Sizewell C (SZC)

Planning Inspectorate Reference: *EN010012*

East Suffolk Council comments on Deadline 8 submissions from the Applicant

9.13 Sizewell C Coastal Defences Design Report [[REP8-096](#)]

DRAWING TITLE:
PERMANENT COASTAL DEFENCE FEATURE
TYPICAL SECTIONS (MAIN)

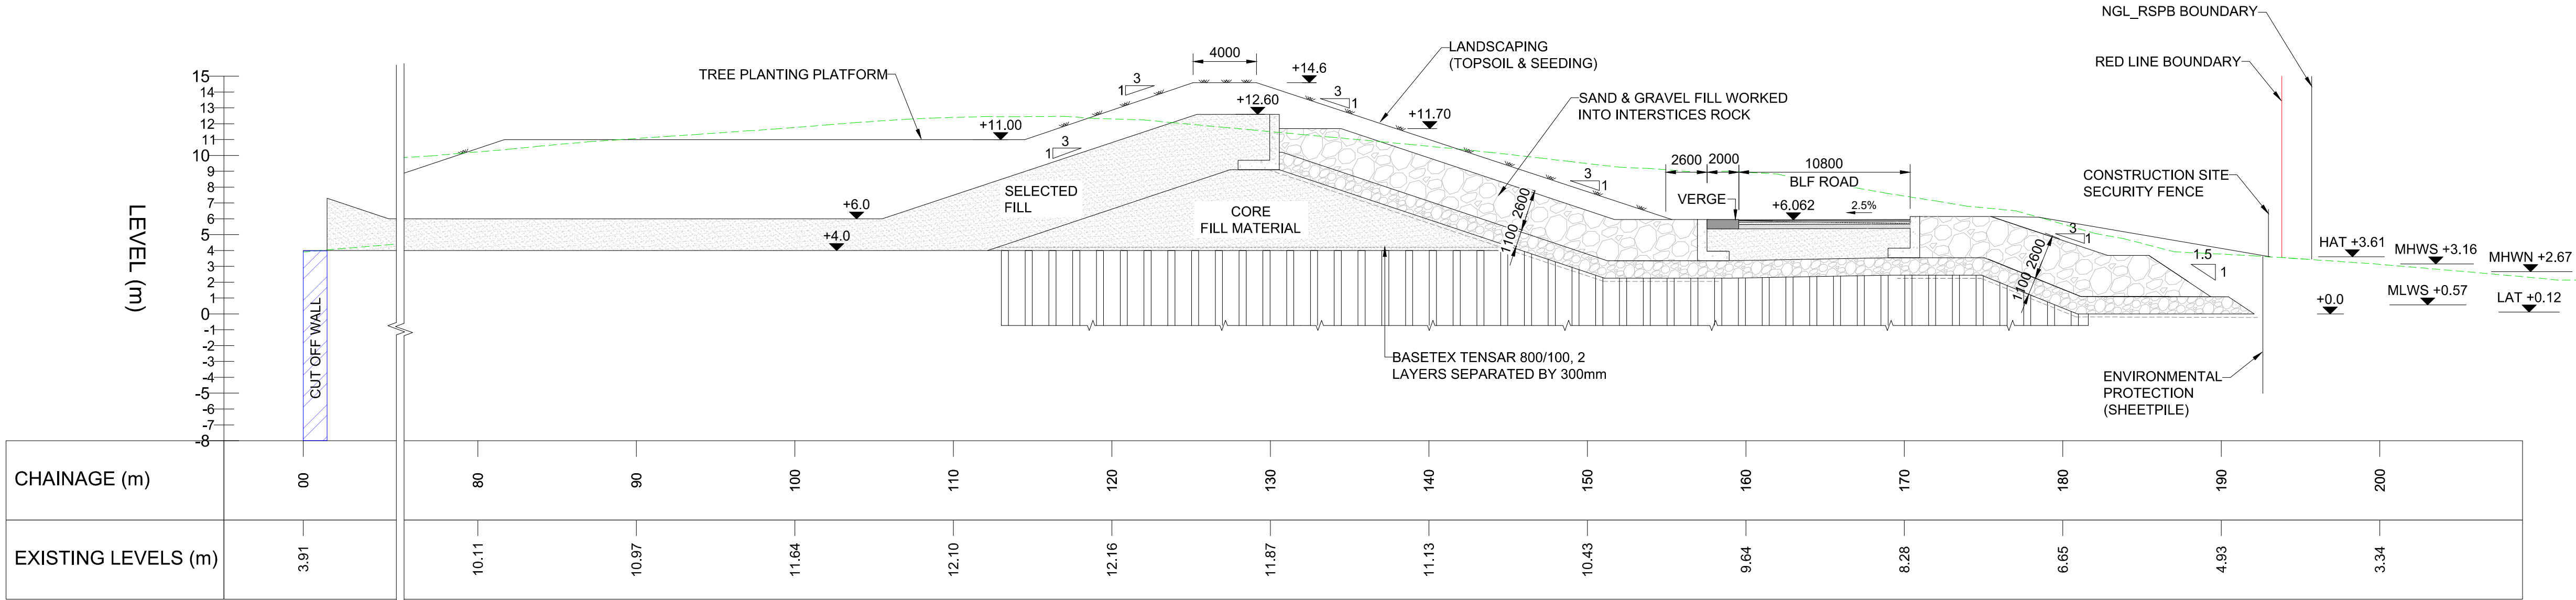
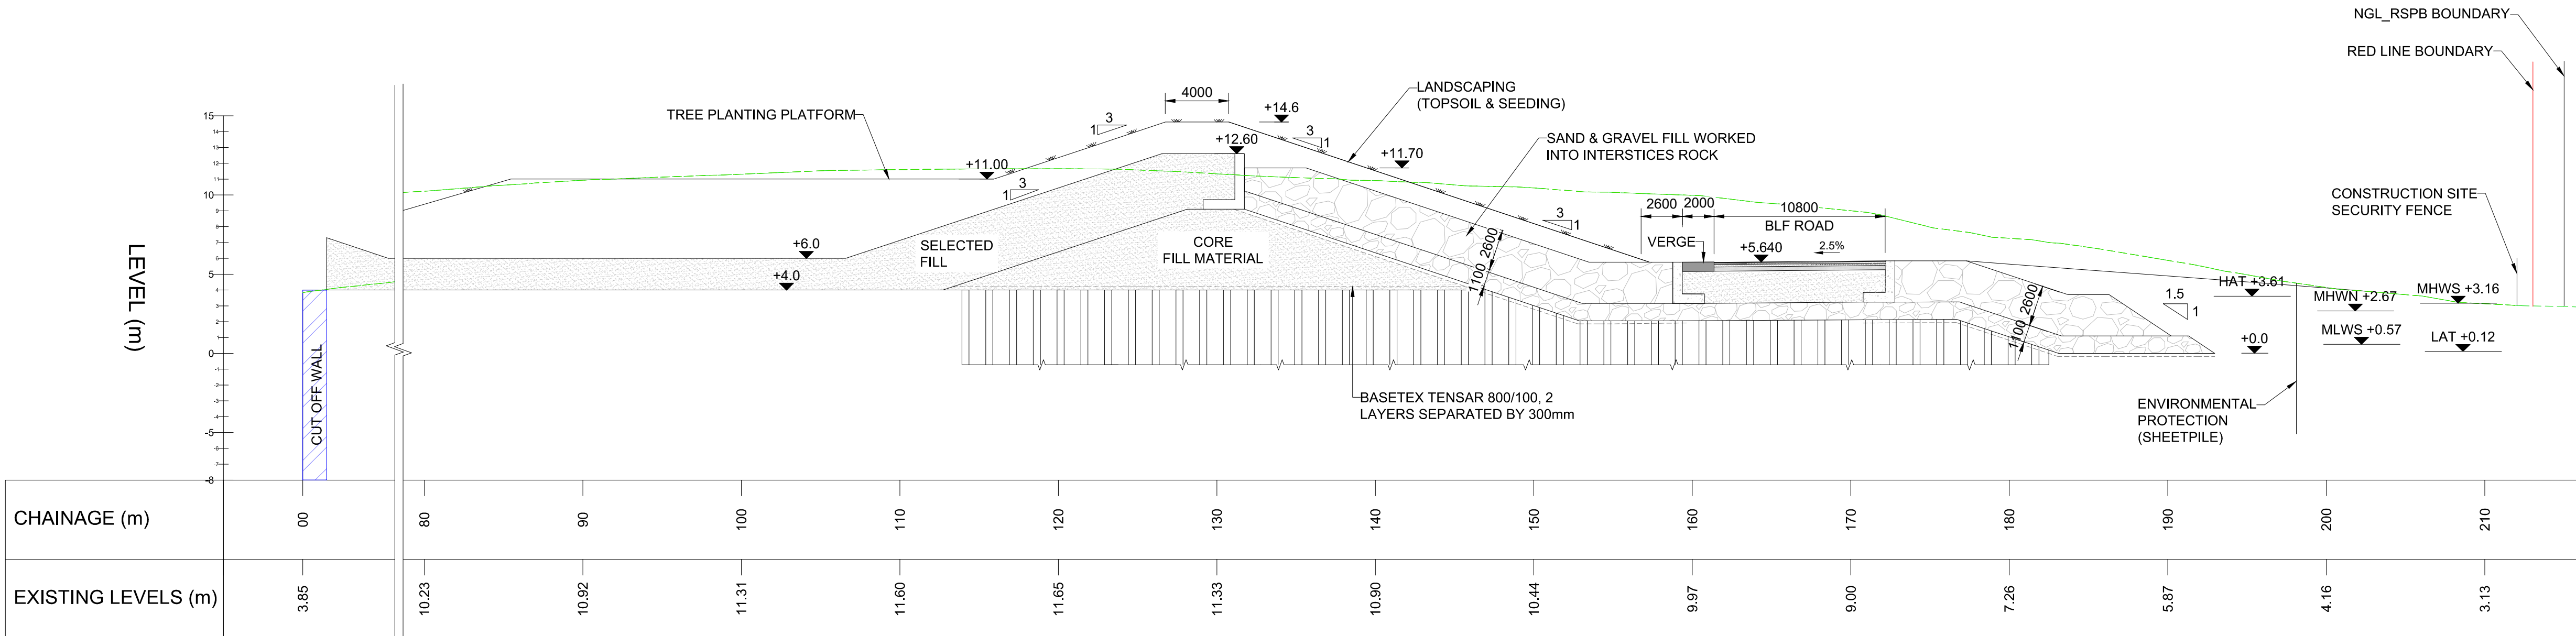
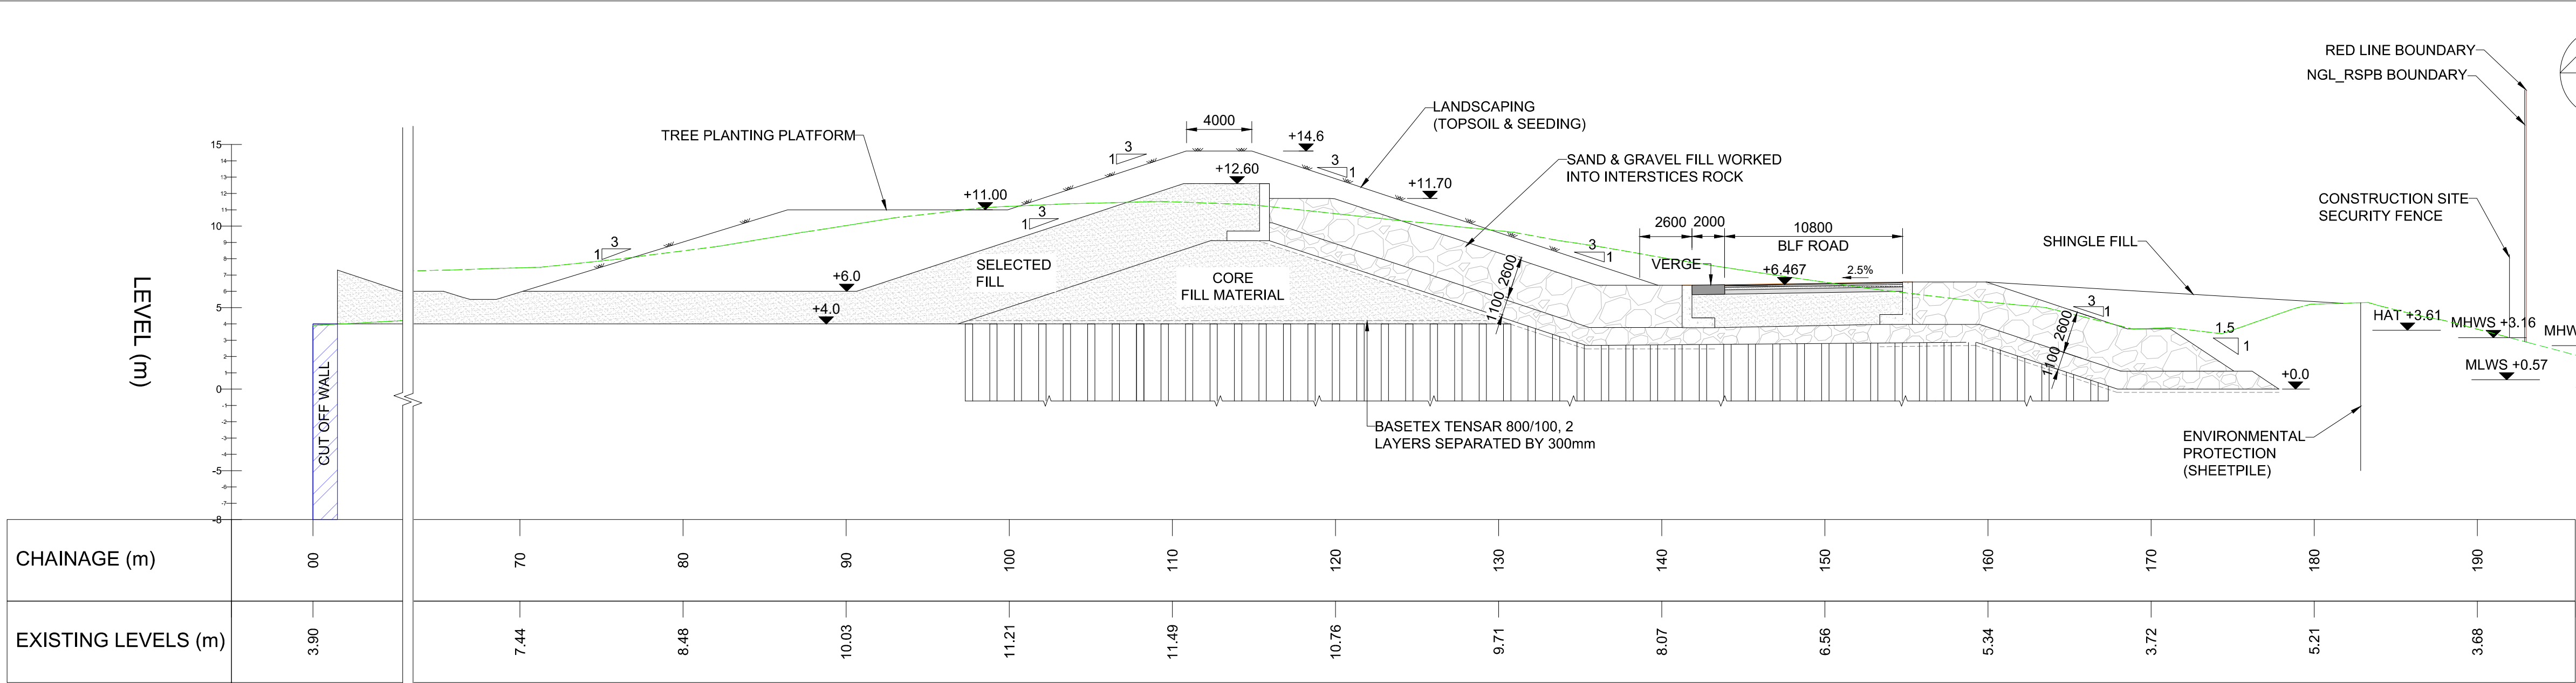
3.4.3	<p>Figure 3-5 – Permanent Sea Defence, Typical Cross-section and Northern Mound</p> 	<p>3.4.3 The seaward toe of the sea defence extends approximately 3m further east (seaward) than in the original DCO submission. This change in seaward extent between the current design and the May 2020 version is driven by the change in crest level of the Permanent Sea Defence (+10.2mOD in May 2020 submission, increasing to +12.6mOD in the change submission) and the minimum 5m standoff to the outer Sizewell C site fence that fixes the landward (western) boundary. This security standoff represents a minimum value that was already assumed in the May 2020 DCO application in order to minimise the Sizewell C footprint. The increase in crest height is due to the increase in climate change allowance between UKCP09 and UKCP18 and the extended design life of the sea defence.</p>	<p>Clarification: The section is designed to avoid the RSPB boundary. Please show section on plan. How does this feature “rotate” (roundhead) to align with the now realigned HCDF at the north end?</p>

3.3.3	<p><i>The seaward toe of the sea defence in the January 2021 Change submission extends</i></p>	<p>See related comment in 3.9.11.</p>	<p>How far has the HCDF toe extended seaward at</p>

<i>approximately 8m further east (seaward) than in the original DCO submission. This change in seaward extent is driven by the change in crest level of the Permanent Sea Defence (+10.2mOD in May 2020 submission, increasing to +12.6mOD in the change submission) and the minimum 5m standoff to the outer Sizewell C site fence that fixes the landward (western) boundary.</i>		amended south end Sizewell B overlap detail? Assumed 26m.
